CLIENT: HIGHWAYS AGENCY

PROJECT: THE VINERY – ACCESS ROAD TO REAR DEVELOPMENT
REVIEW OF MODIFIED ACCESS, NMU CONTEXT REPORT AND RSA BRIEF

RESPONSE REF.: TECHNICAL NOTE 02 (TN02)

2 REVISED ACCESS DRAWING (35201-102 REV. C)

PROPOSED SITE PLAN

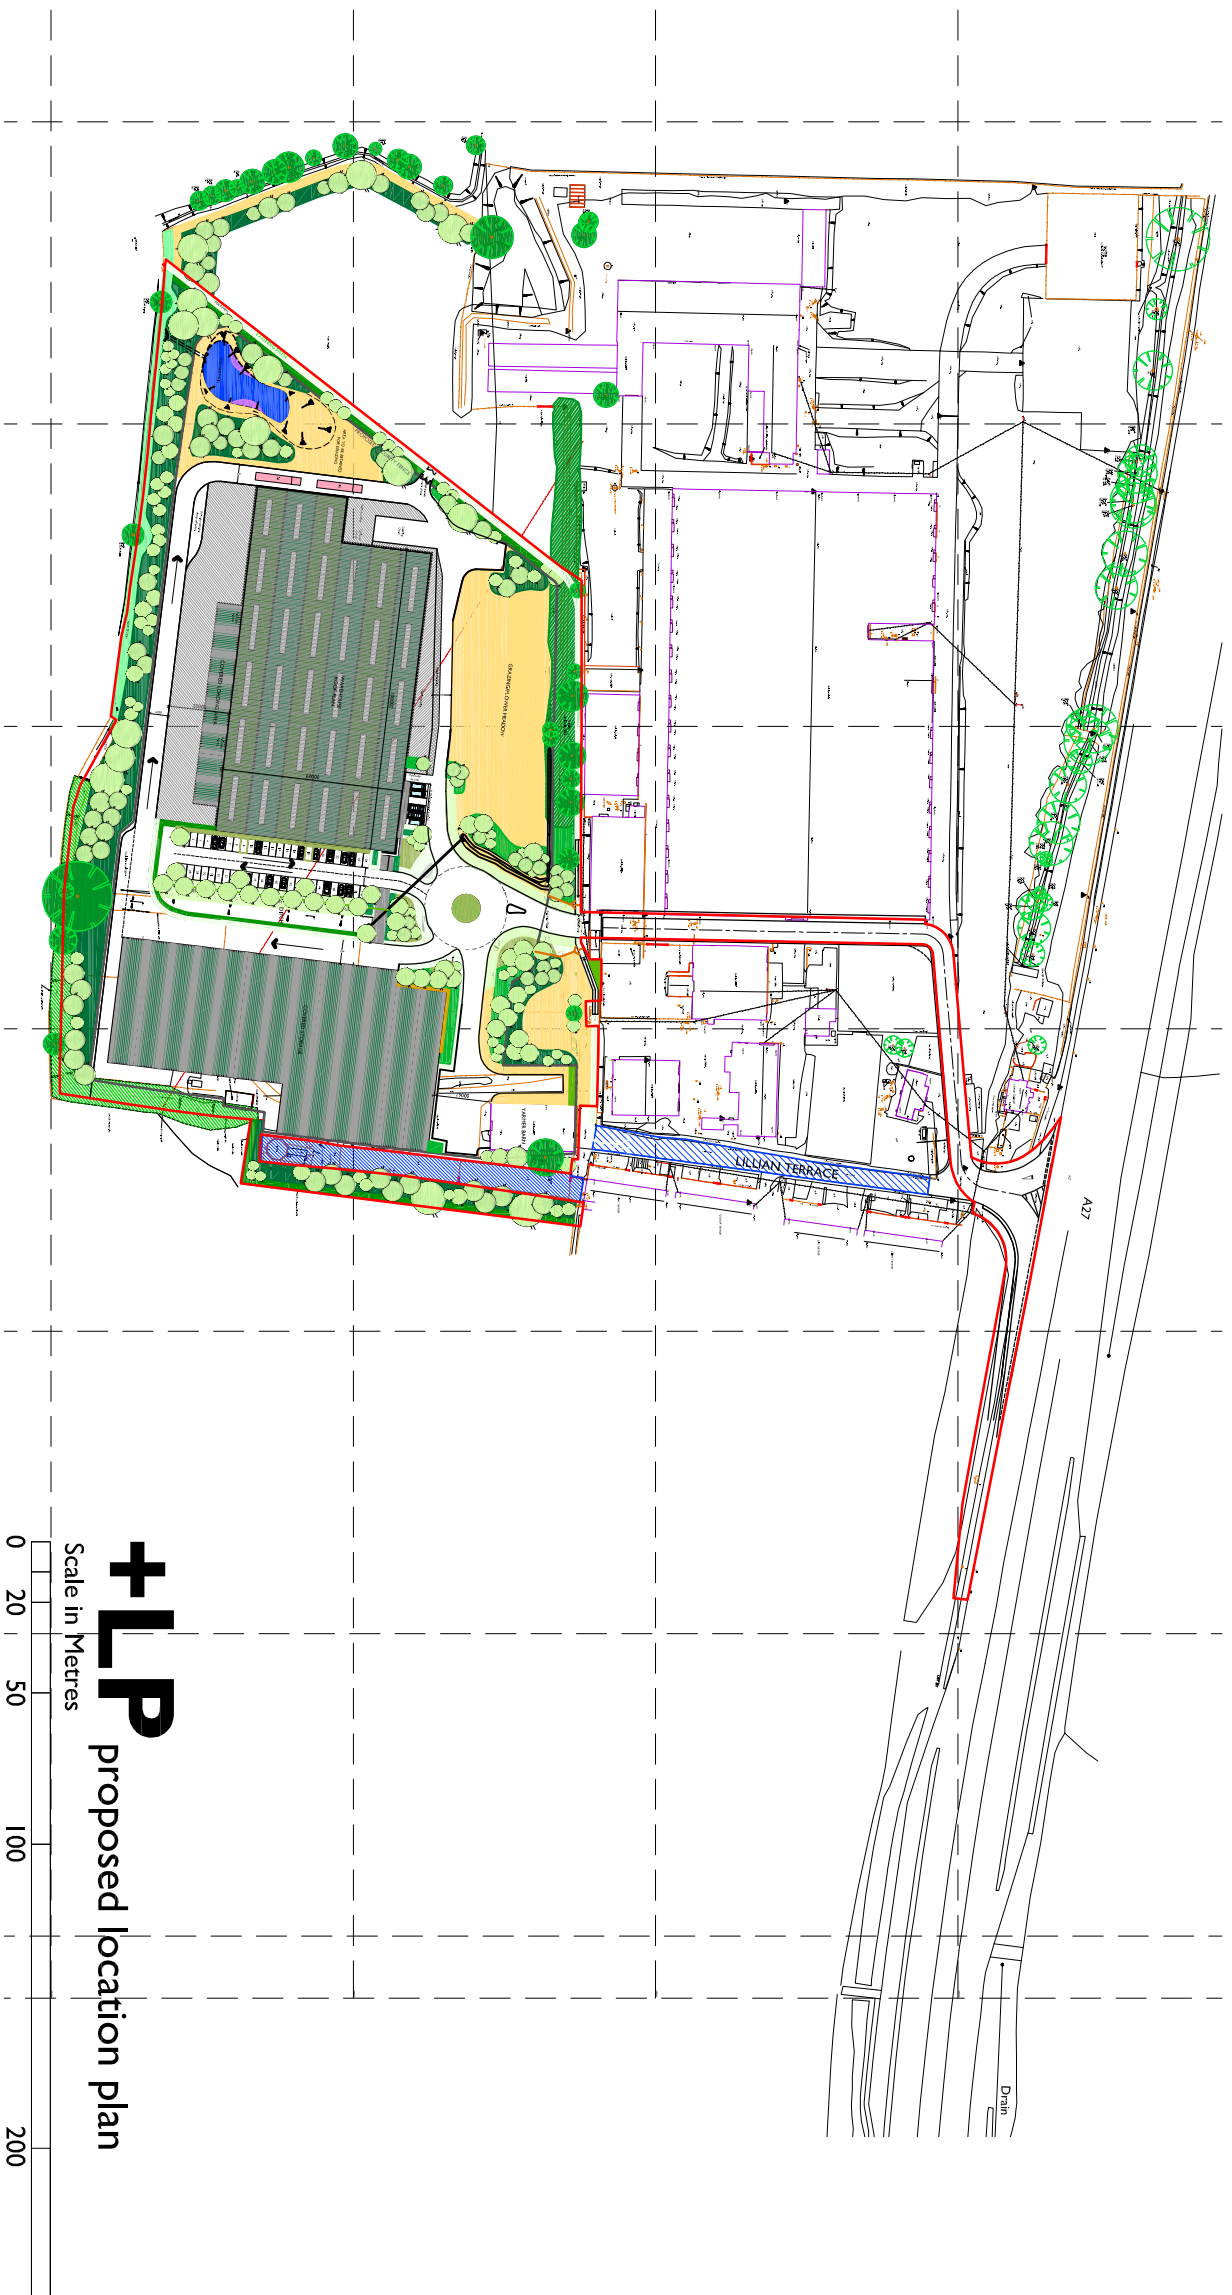
- 2.1.1 PB's TN01 identified that the exit taper is one step below the deceleration length set out in TD 42/95, table 7/5b, and that this is a significant improvement over the existing situation. It is also noted that the HA letter to Arun District Council recommended that existing and predicted traffic flow information still needs to be provided. This traffic flow information may raise the threshold at which the proposed taper is deemed inadequate and an auxiliary lane needs to be provided instead. The access radii will also need increasing to 40m to meet TD 42/95, paragraph 7.54. Departures from Standard will need submitting and approving, for the current design to be approved, for the use of access radii less than 40m on a dual carriageway with a design speed in excess of 85kph.

- 2.1.2 In addition, the existing access has a diverge taper of approximately 40m in length, the start of which being approximately 85m from the exit merge of a lay-by on the westbound A27. Lengthening the diverge taper into the site will reduce the distance between the lay-by and the access to 45m, highlighting the fact that the distance between the lay-by and this access is sub-standard, according to TD 69/07, paragraph 3.7. This states that, to avoid conflicts between vehicle accelerating from the lay-by and those decelerating to enter an access or junction "... the separation distance between a lay-by and nearest junction or access must be $3.75V$ metres where V is the design speed in km/hr". Starting the diverge taper into The Vinery nearer the lay-by is also likely, therefore, to require the submission of the Departure from Standard.

- Predicted increase in NMU flows to and from the site – the design of the modified access relocates the NMU crossing further away from the A27, resulting in NMUs having to turn a right angle when commencing and completing the crossing of the access road. If multiple NMUs cross simultaneously the width of the facility may need increasing so that opposing NMUs do not obstruct one another

- 4.1.1 The draft RSA1 brief is not in accordance with HD 19/03 as it lacks the following information:
- A Departure from Standard relating to the use of sub-standard access radii; 20m instead of the minimum 40m required for a design speed in excess of 85kph
 - A Departure from Standard relating to the close proximity of the improved access to the lay-by just upstream of the access on the A27
 - Existing and forecast traffic flows
 - NMU existing and forecast flows on the A27 and the Right of Way through the site
 - NMU desire lines
 - Previous 36 months accident data for the A27 in the vicinity of both the lay-by just to the east, and the site access
- 4.1.2 Although not in required by HD 19/03 road safety briefs also now require the results of the NMU audit, or consideration of the NMU Context Report by the HA, to be included for consideration by the road safety audit team.

- 5.1.1 The applicant needs to carry out traffic and NMU surveys, and provide predicted traffic flow and NMU flows passing and into the site, in order the meet the requirements for additional information in both sections 3 and 4 above.
- 5.1.2 The implications of the Right of Way affected by the proposal needs to be considered and documented.
- 5.1.3 36 months of accident information needs to be sought from Sussex Police and analysed for the stretch of the A27 in the vicinity of the lay-by and access to The Vinery.
- 5.1.4 The applicant also needs to bear in mind that there are two further Departures from Standard that need to be submitted, as detailed in 4.1.1 above.
